Environmental Health: Application for Discharge of Condition 36, in respect of those properties TR1-10 alone
The Environmental Statement, Volume 1, February 2011, p 275, paragraph 10.6.2, 'Operational Noise' highlighted that properties bordering the east of the proposed Lyminster Bypass at Toddington Park were considered likely to require noise mitigation during the operational phase of this new road, namely a 2m minimum height acoustic timber barrier. That Noise Assessment prepared by WYG, August 2017 in respect of discharge of the above Condition proposes a 3m high acoustic barrier to extend around properties referred to as R1-R7 on Drawing Number SK02 and somewhat to the north of this; of given construction (Appendix C) which, it is stated, will achieve noise attenuation of up to 7.4dB (p18). Whereas this approximates to the location of Number 9 to 23 Toddington Park, please provide clarification as to which dwellings these references pertain.

APPLICATION LU/278/17/RES

Site Address: North Littlehampton Strategic Development Site Land West of
Toddington Park, Toddington Lane Littlehampton BN17 7PP

Description of Works: Approval of Reserved Matters following Outline Permission

Landscape Proposals SLB2

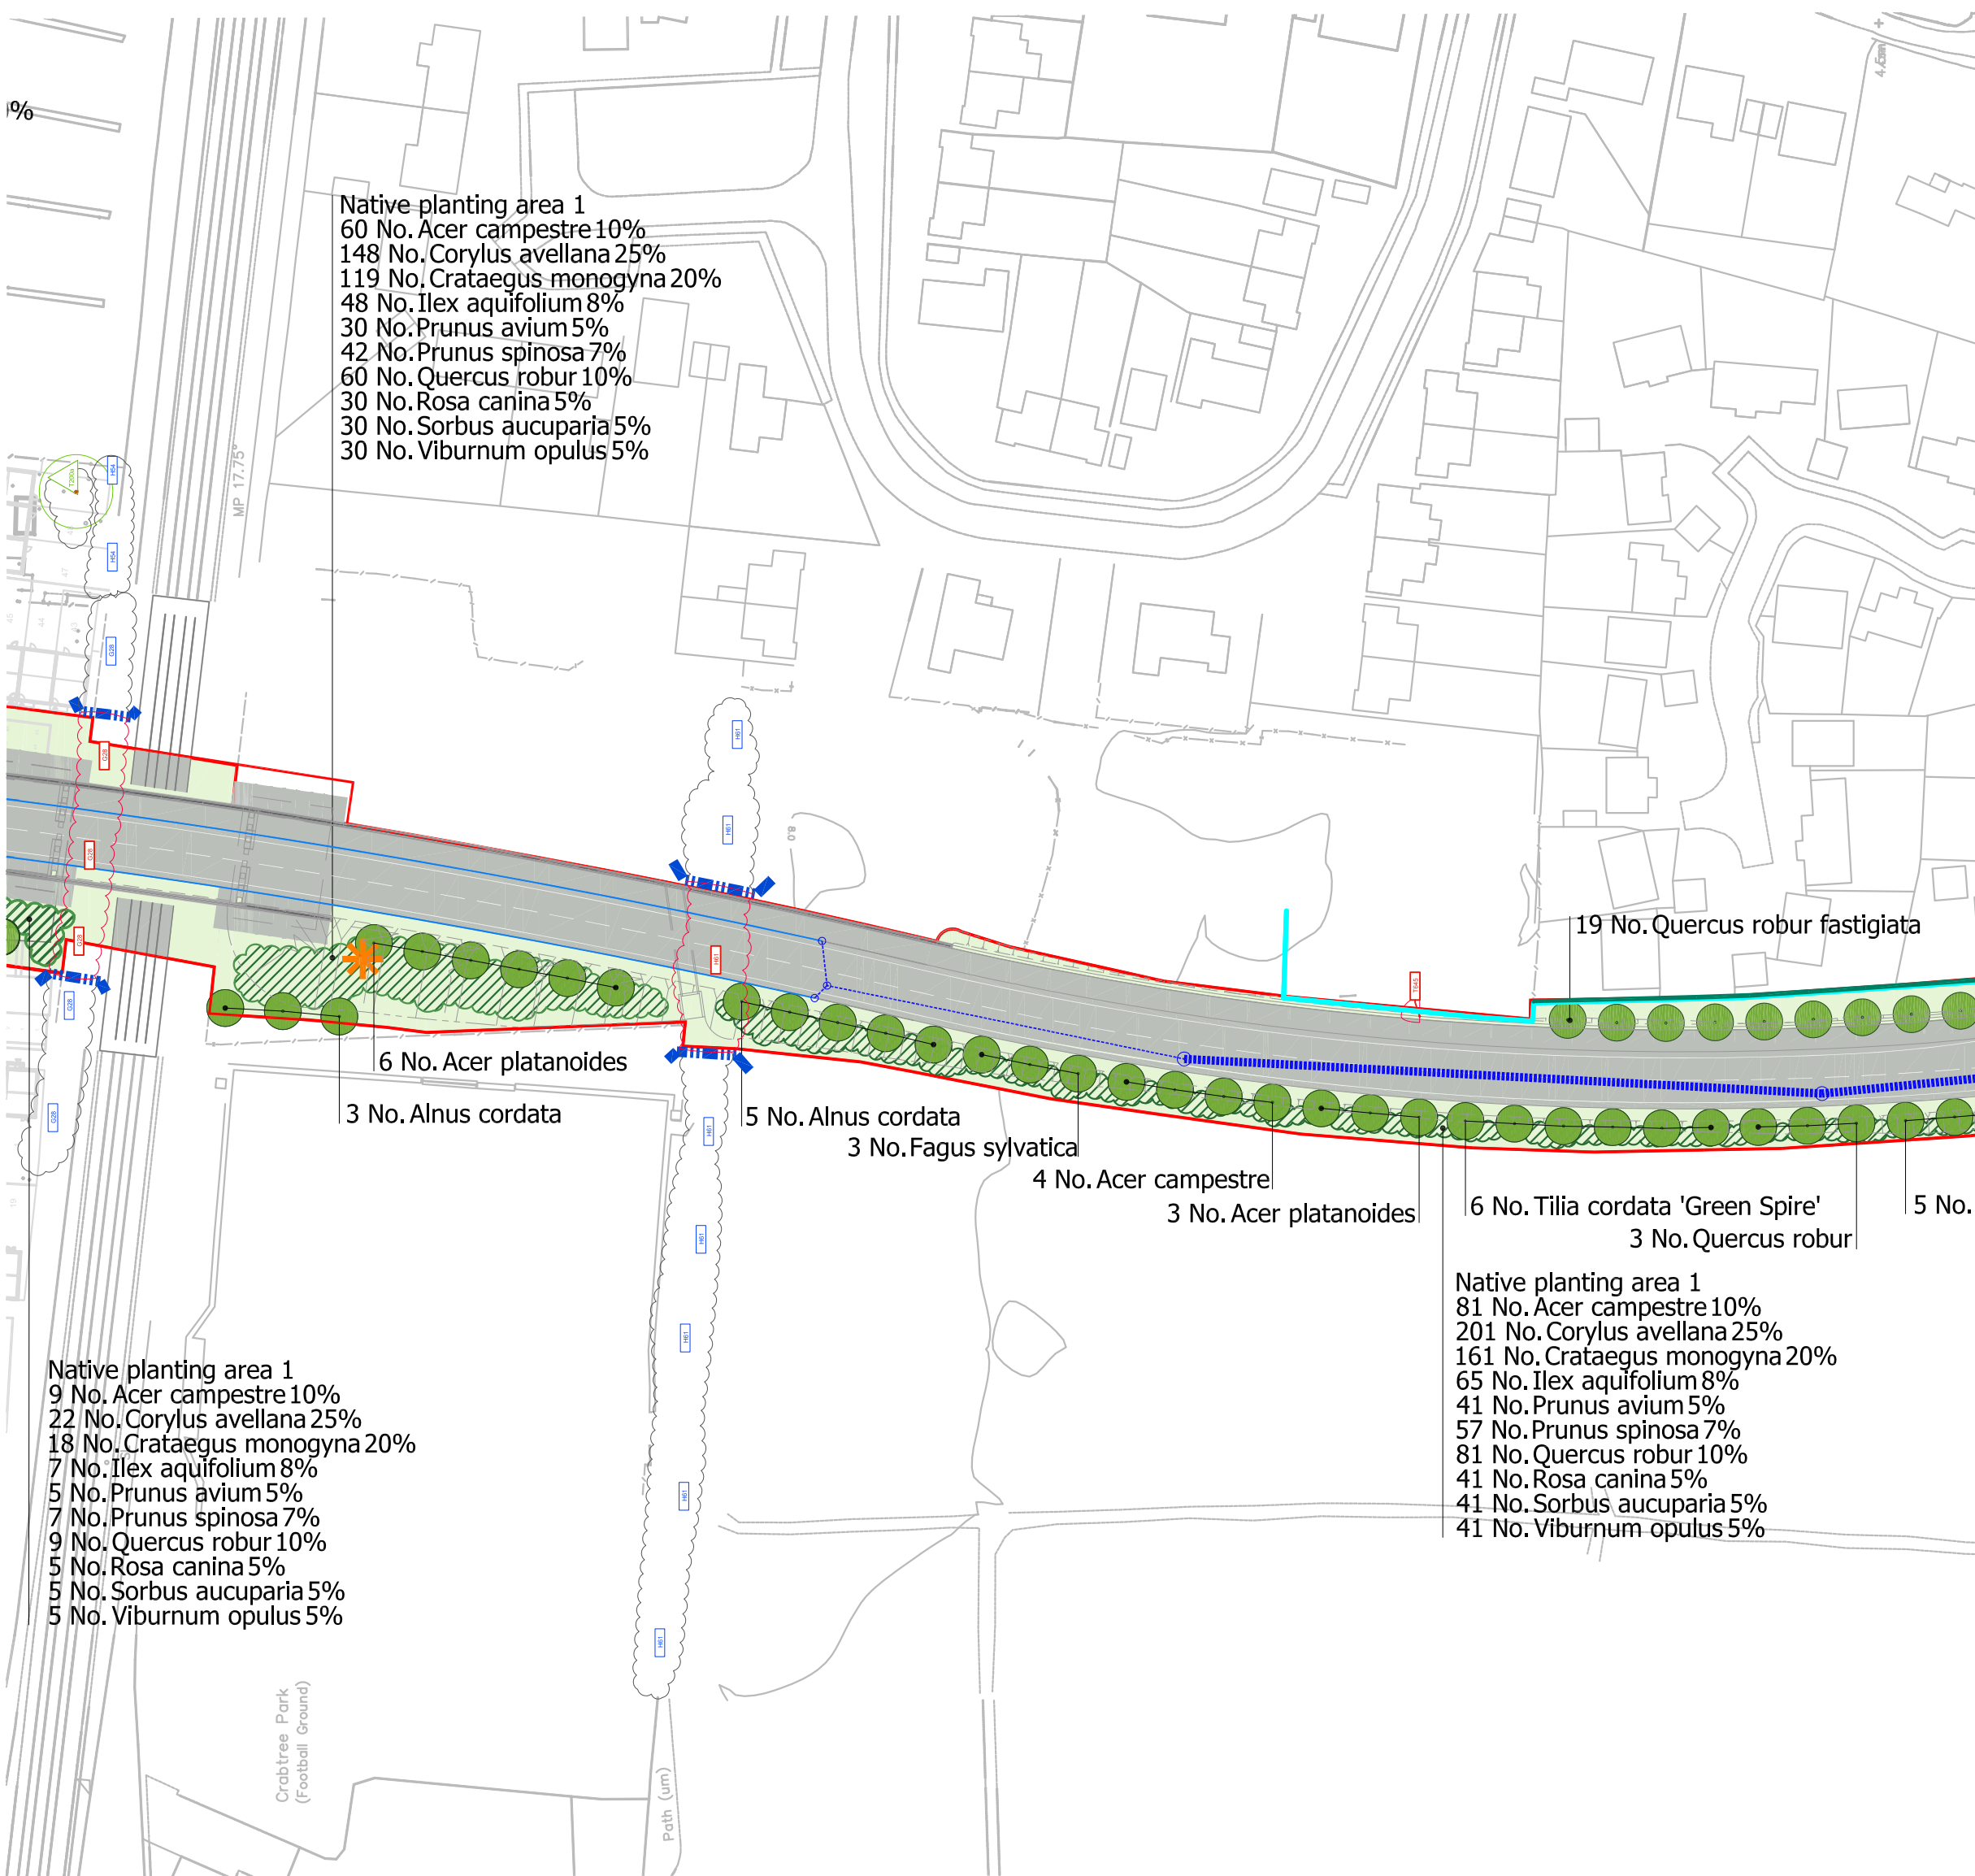
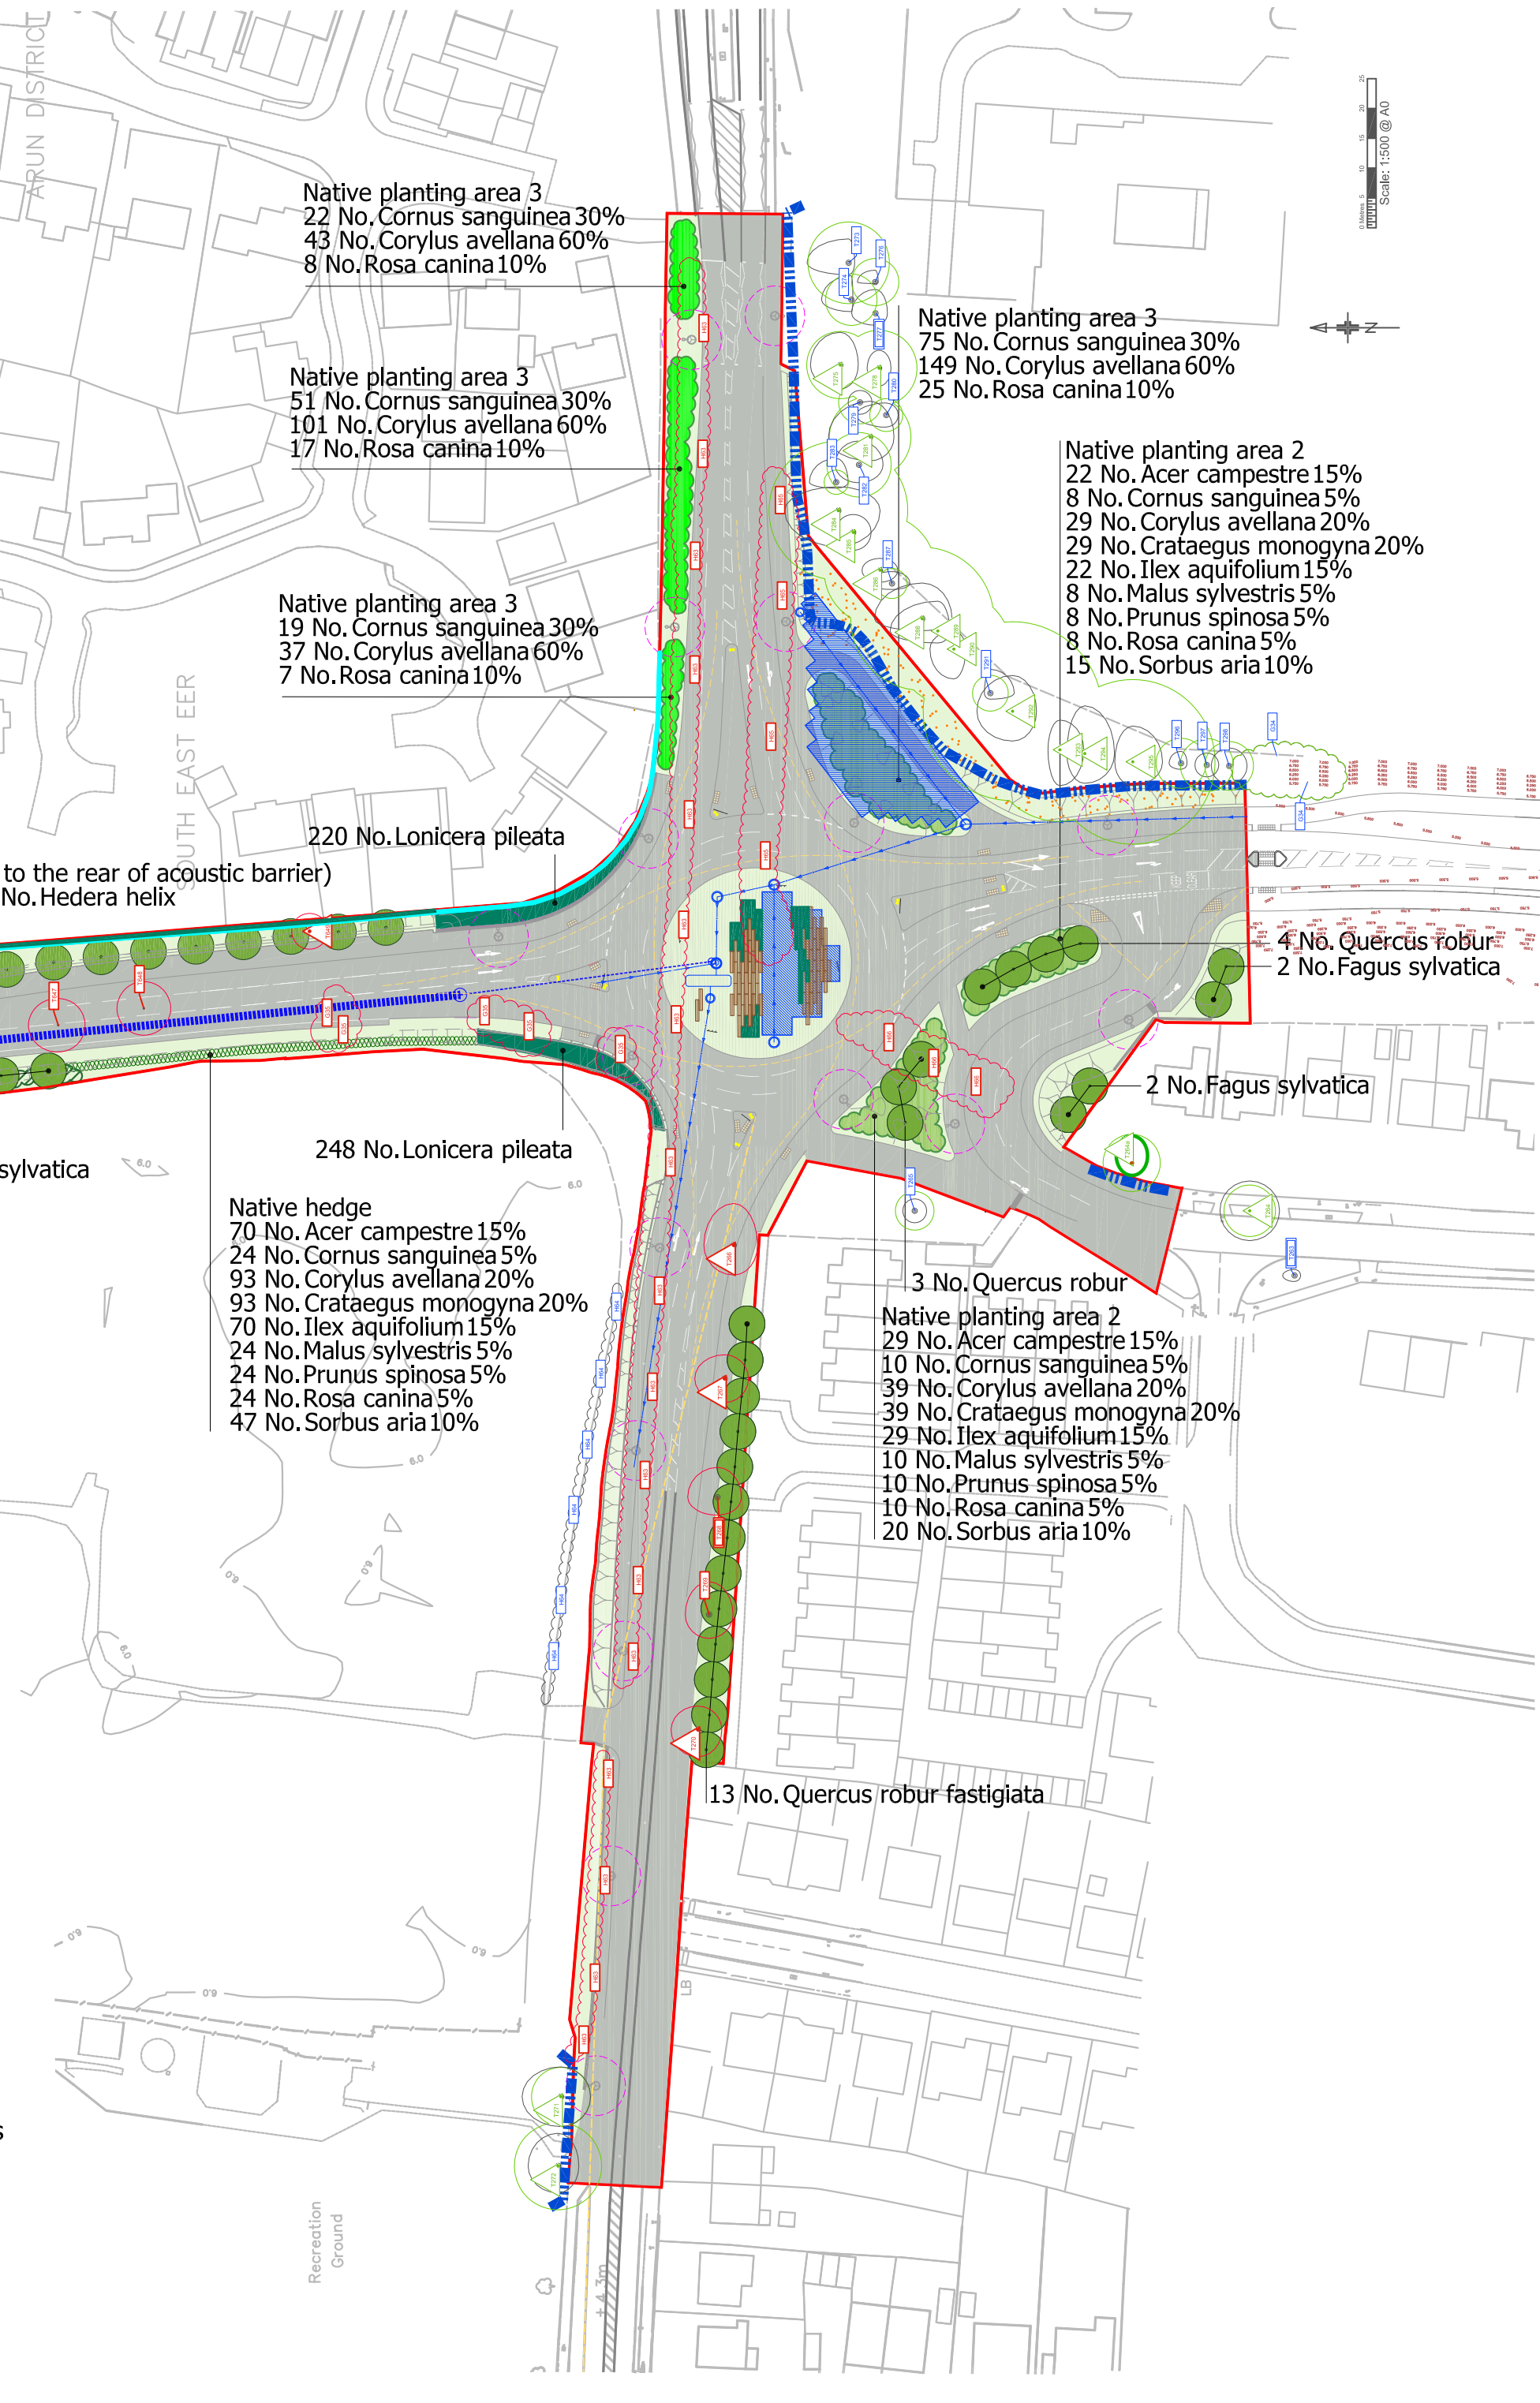
The report also references Table 6.2 as demonstrating that all representative receptors listed would have 'negligible to only slight adverse impact,' with such a 3m barrier in place. However, whereas the increase in noise experienced by properties TR1, 2, 3 and 4 (Nos 10-13 Toddington Park) is stated as 'minimal/negligible,' properties TR5, 7 and 9 (Nos 14, 22 and 23 Toddington Park) are expected to experience both 'moderate adverse impact' and, TR6, TR8 and TR10 (Nos 14, 22 and 23 again) 'significant adverse impact.' I would be obliged if you would explain the disparity in these statements and the way in which noise levels experienced by these properties will comply with guidance contained in B58233 (2014) – "Guidance on sound insulation and noise reduction for buildings," both in habitable rooms and the amenity space to these dwellings, as described in p254/5, s10.3.6 of the above Environmental Statement.
